7th March 2018

I am writing in objection to application A/8/18/PL for the land behind 1 – 6 The Cottrells.

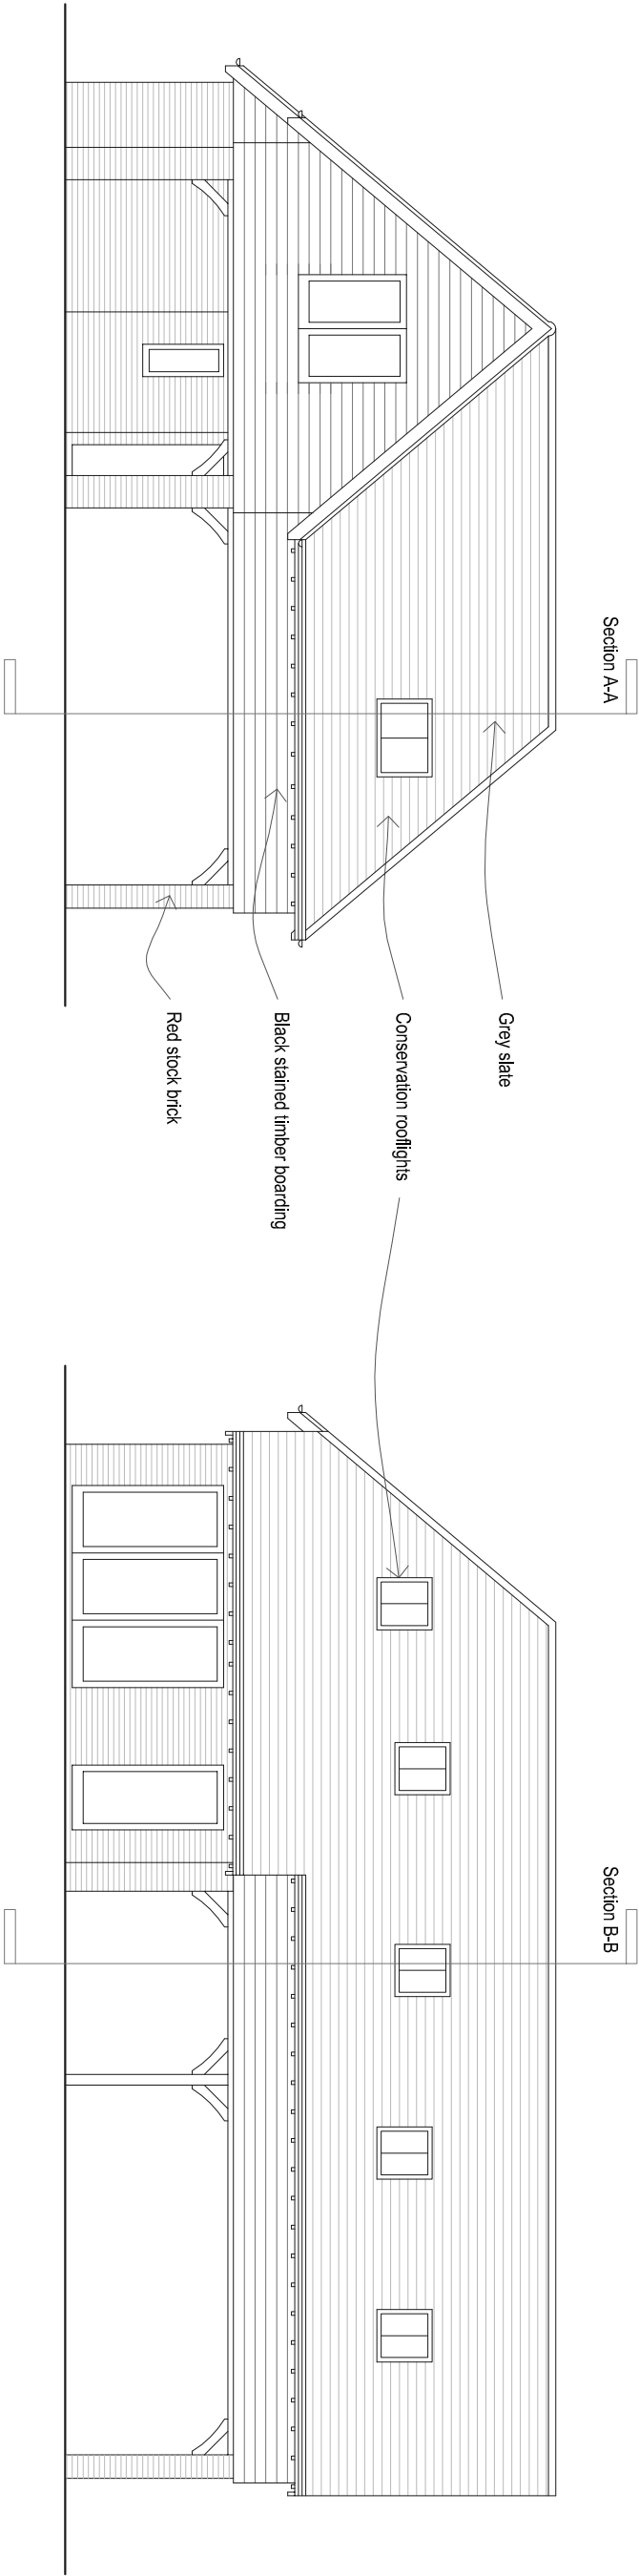
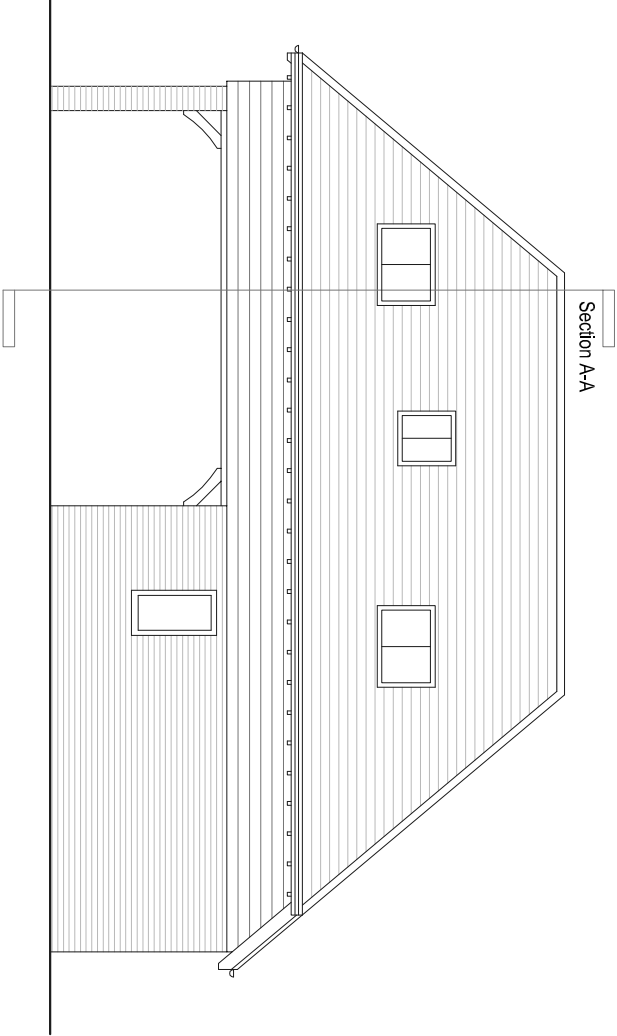
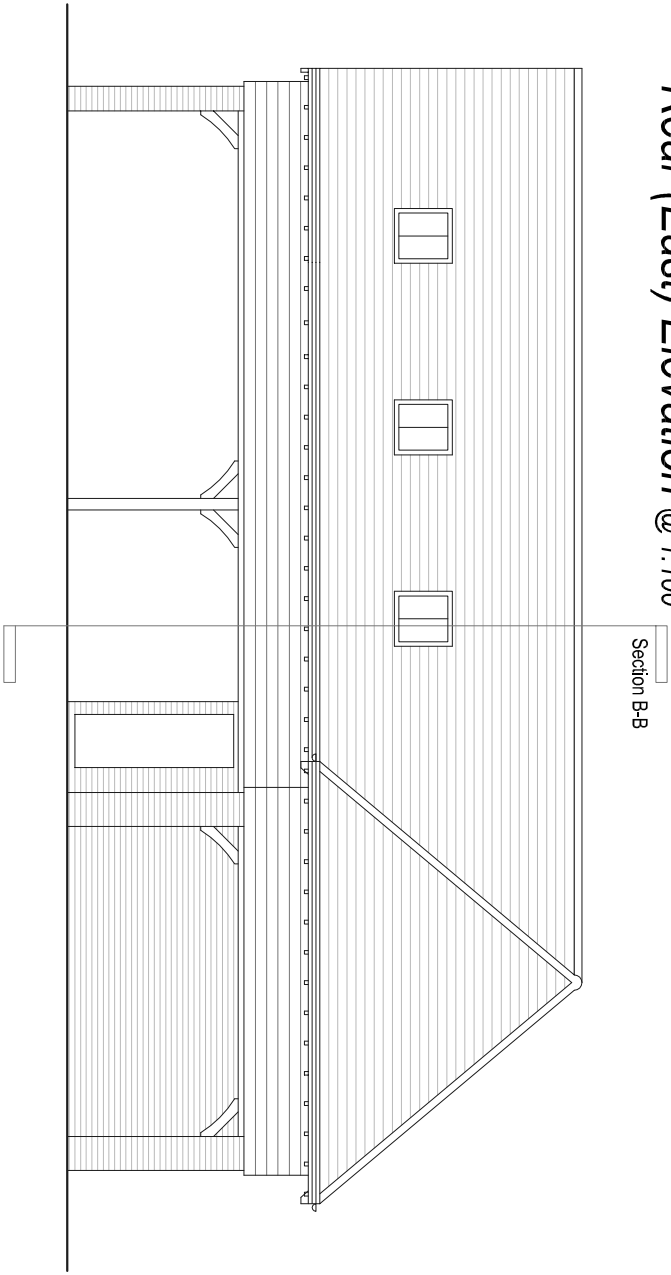
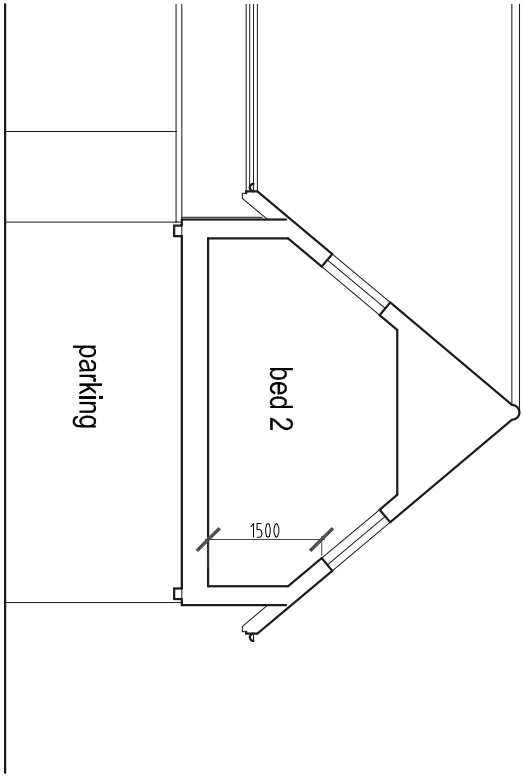
The rooflights that have been put in place are at a different height and of a different type to the ones shown in the approved plans. The windows that have been installed appear to be ordinary Velux and not the escape heritage rooflights that were passed in planning. The lowered heights of the windows mean they look straight into the rear bedrooms of 1 – 6 The Cottrells and greatly affects our privacy. We now keep the blinds shut permanently to prevent our privacy being invaded and do not look forward to being able to watch our future neighbour as they sit in their living room. This objection is as much for the future resident's privacy as ours. Has the development been

granted special permission to put the rooflights at a lower height or is this another modification the developer has seen fit to put in?
